***RE: Grading and Drainage Certification for Desert Flower Subdivision Unit Two,
(M10/D12D), Engineer's Certification Stamp Dated 12/21/98.***

RE: Revised Drainage Report for Desert Flower Subdivision, Unit Two, Dated 5/18/98, and Grading and Drainage Plan, Dated 6/9/98, (M10/D12B) Submitted for Preliminary and Final Plat and Work Order Approval.

REVISED DRAINAGE REPORT
FOR
DESERT FLOWER SUBDIVISION
UNIT TWO

TITLE: **DESERT FLOWER SUBDIVISION--UNIT TWO GRADING & DRAINAGE PLAN**

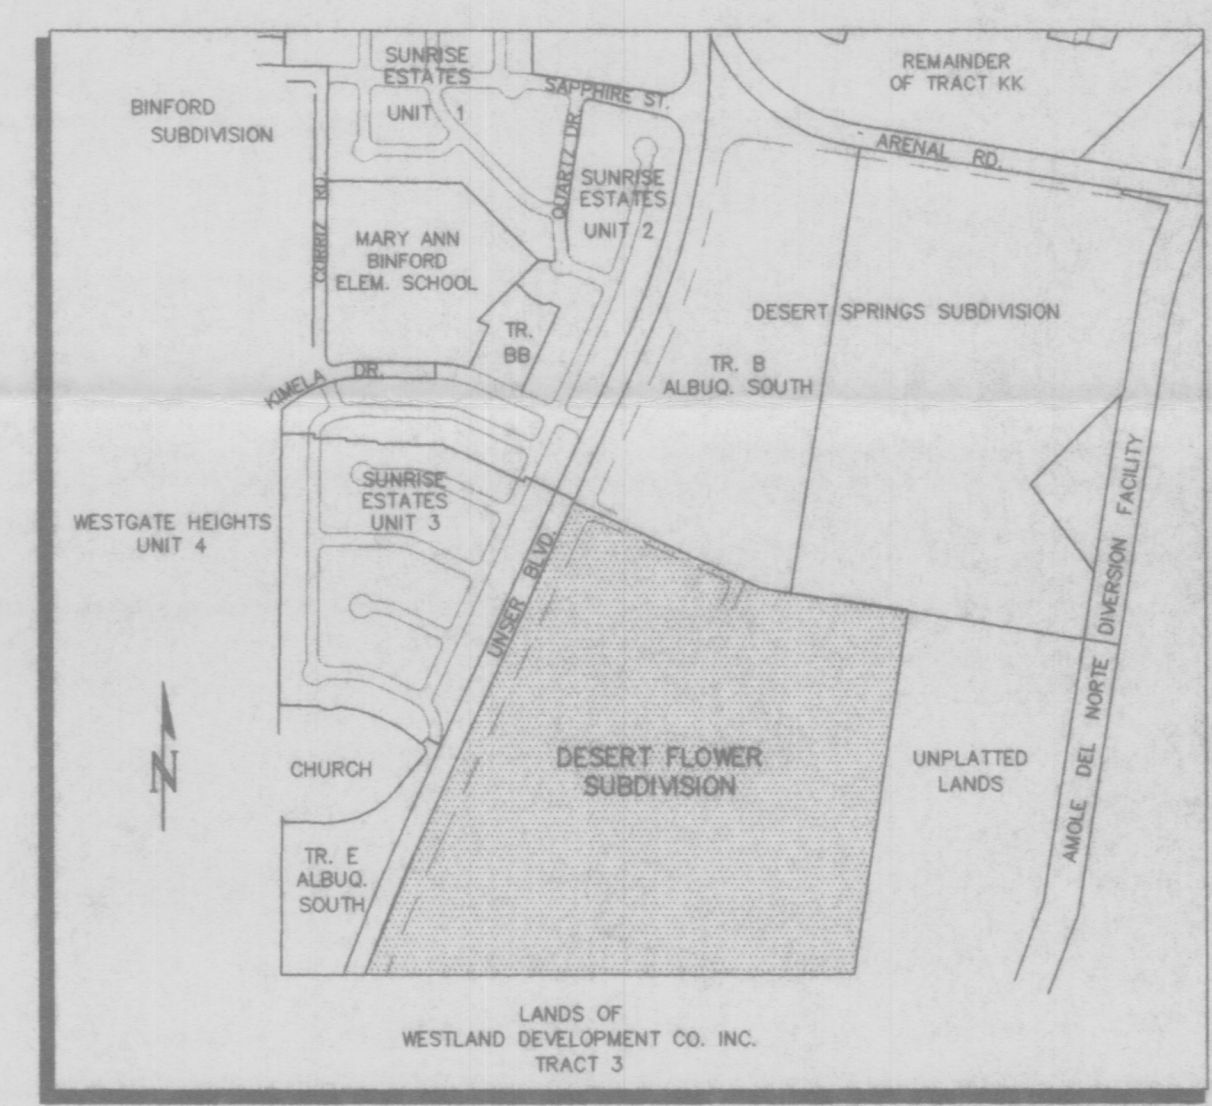
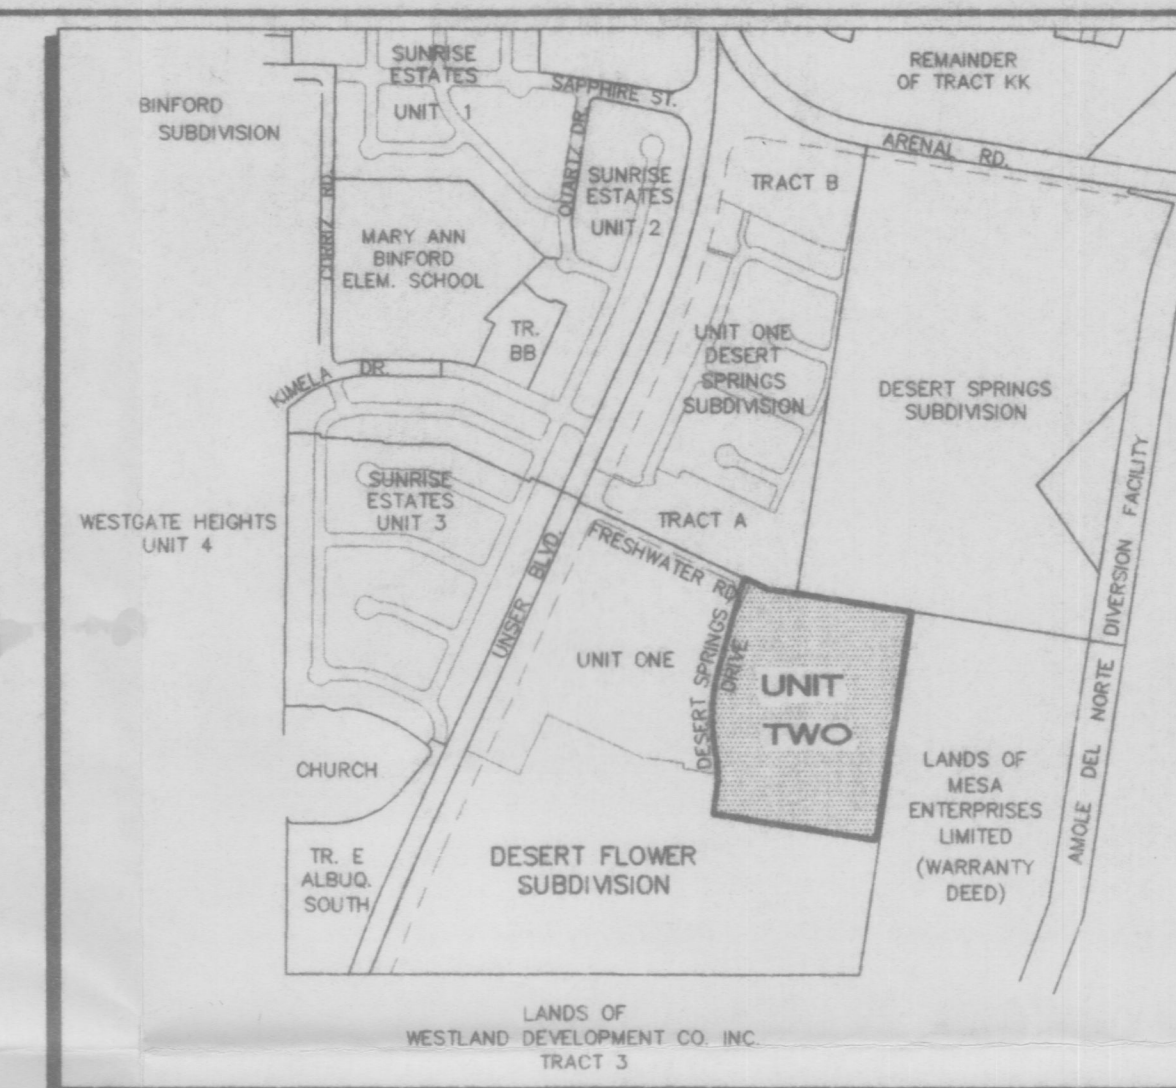
Details showing how the runoff from Spring Canyon Drive gets into the earthen channels will be required at DRC. Before sign-off of the Work Order plans, a public drainage easement must be in place for the temporary drainage channels and pond located on Unit 5. Also, the Agreement and Covenant for the pond must be filed. The SIA must be in place prior to Final plat sign-off.

channels
wide, deep
Look @
grading

Revised by
Fred Arfman
6-16-98 w/
3:1 side slopes
